Our ref: DOC20/509024

Senders ref: SSD10425

**Subject: Clarification on BDAR or BDAR Waiver for Tallawong Station Precinct South – Stage 2 Detailed Design (SSD10425)**

EES has reviewed the Flood Impact Assessment report (FIA) prepared by AECOM dated 16 April 2020 and considered that the report is inadequate due to the following reasons:

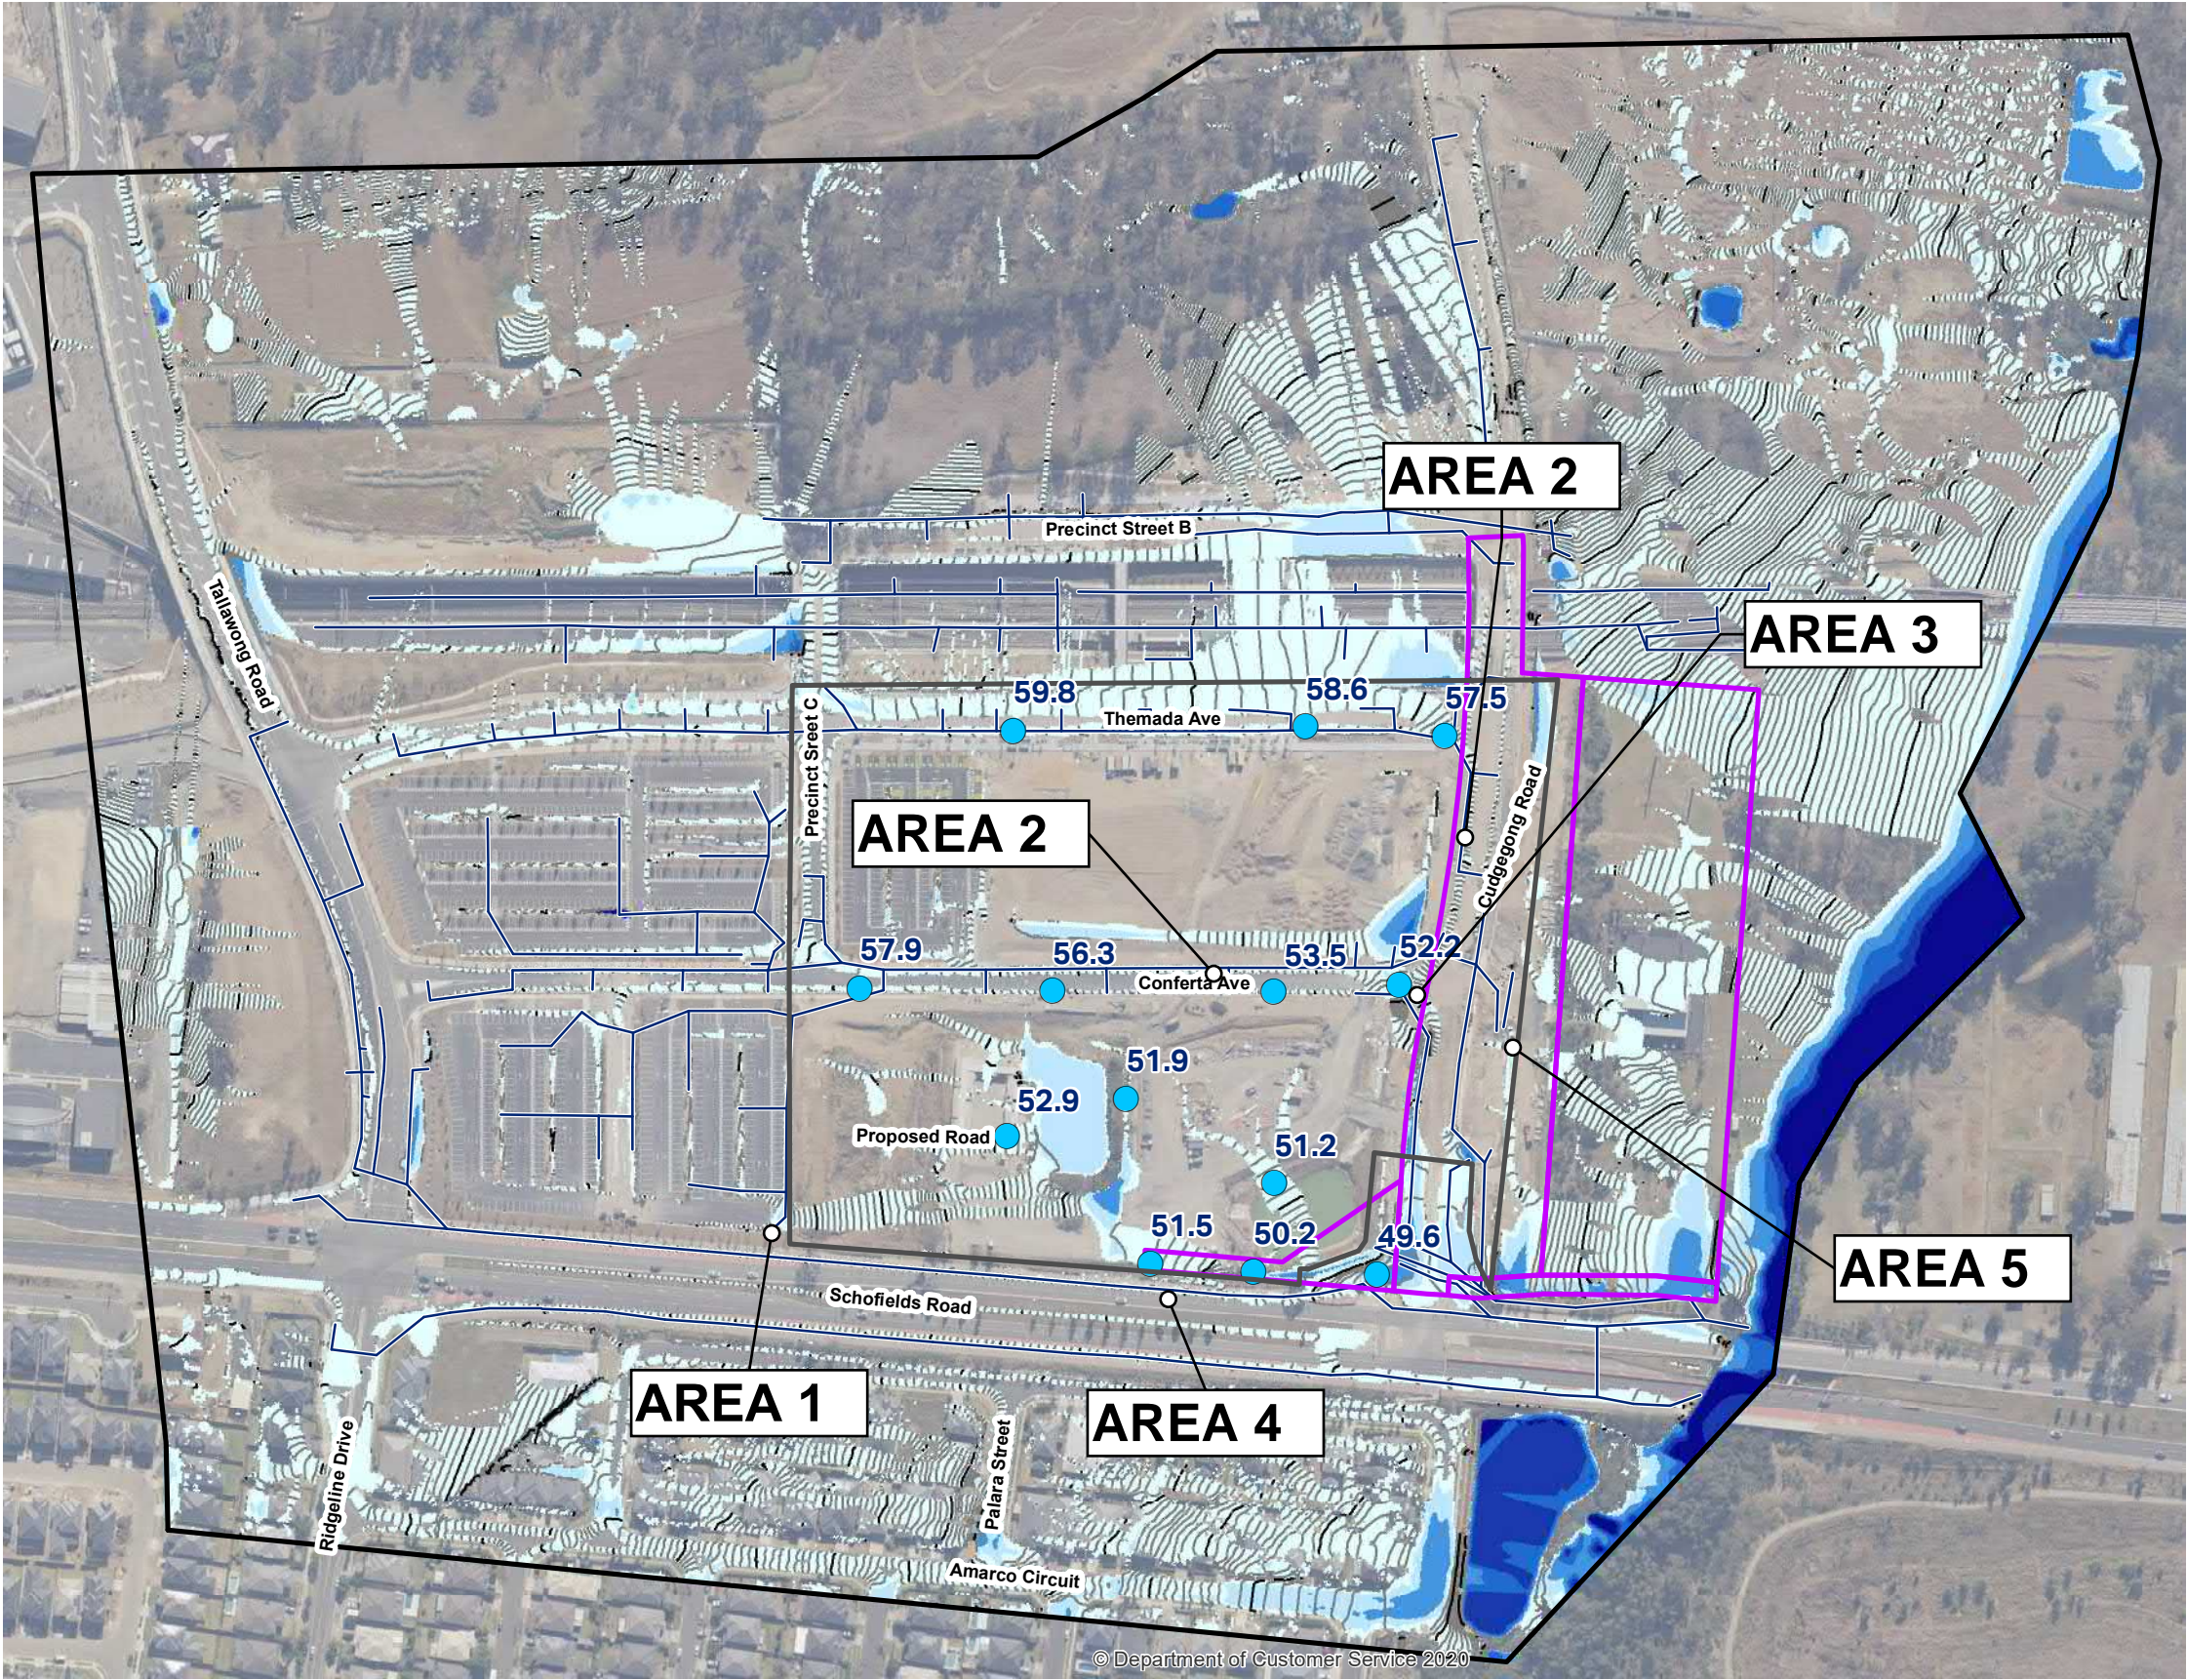
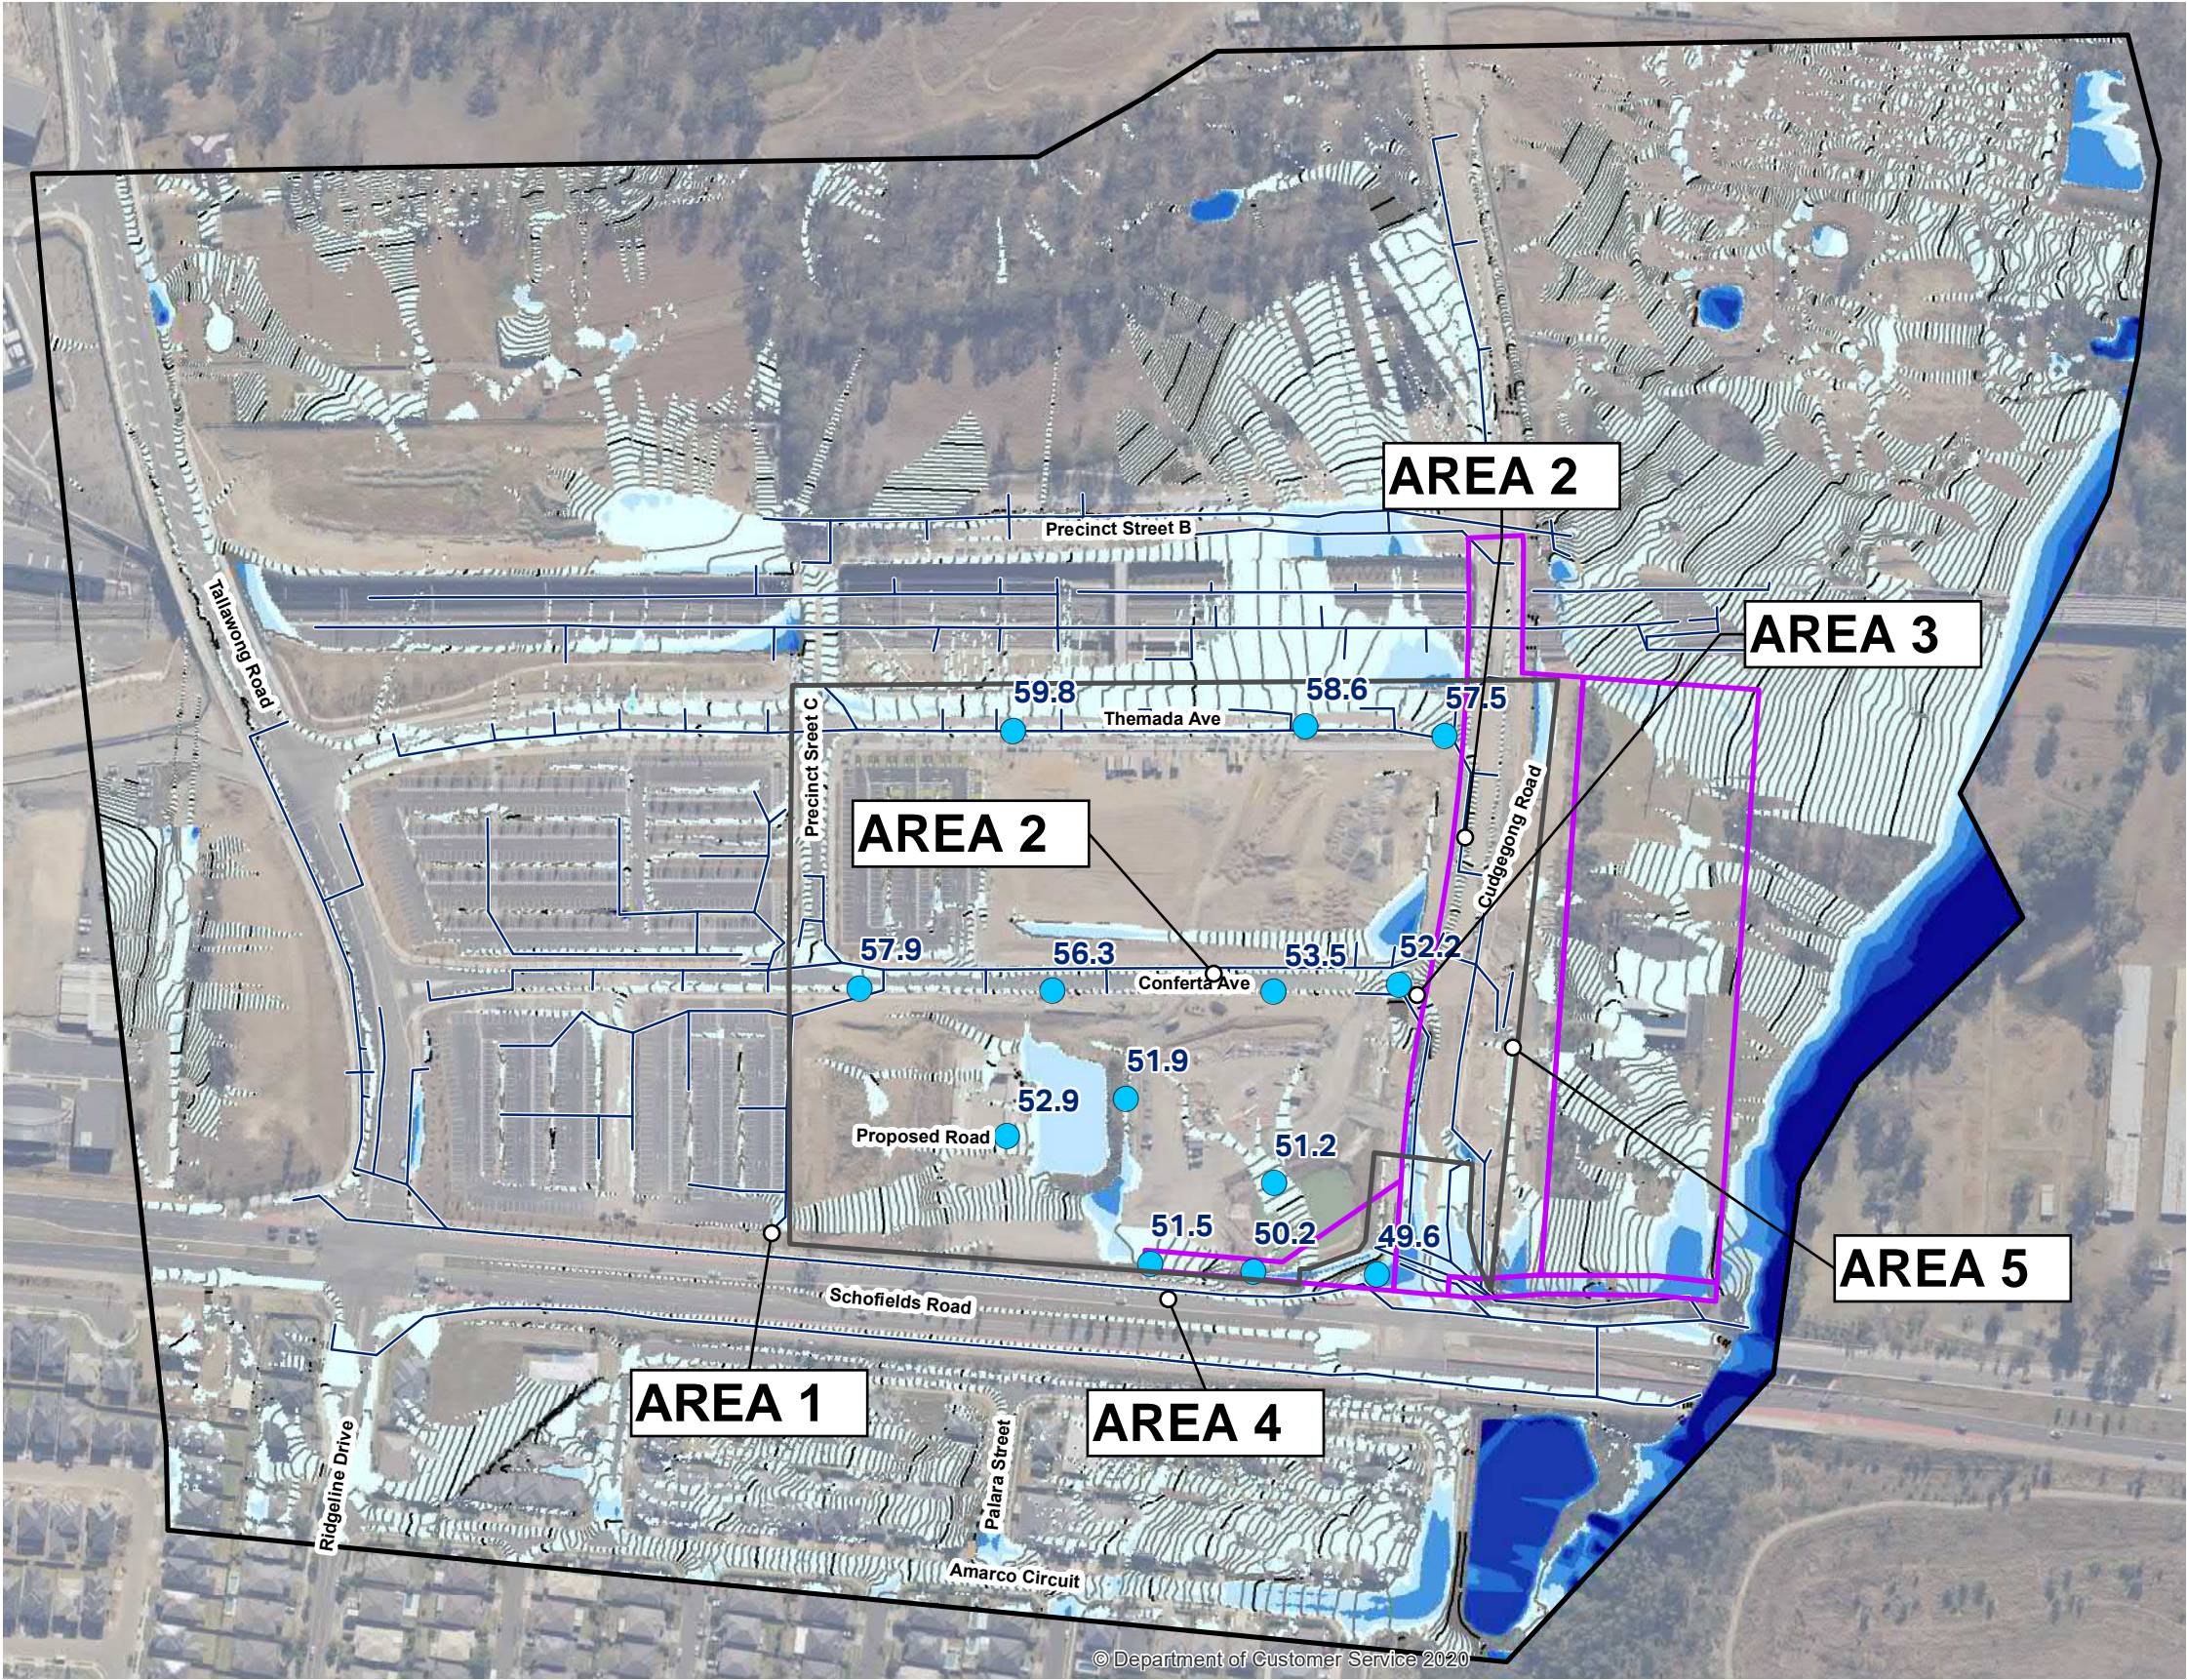
- the report provides no information on existing flood behaviour
- the report lacks details on model results
- not clear what is the extent of the model
- the limit of maps does not show the impacts of development outside of the site, the assessment should map the site and adjacent areas (i.e. to Second Ponds Creek to the west and at the inflow locations where the boundaries of the model were set up).

It is acknowledged from the brief discussion in the report that the consultant has undertaken a rainfall on grid TUFLOW modelling. However, the purpose of a FIA is to outline the flood risk at the site and outline how this risk is to be managed. This would include addressing the following floodplain risk management aspects to assist and guide decision-making at this planning stage:

- existing flood behaviour for the full range of flooding
- impact of development on flood behaviour the full range of flooding
- impact of flooding on development the full range of flooding and assess the compatibility of the proposed development with flood risk
- emergency management consideration (if applicable).
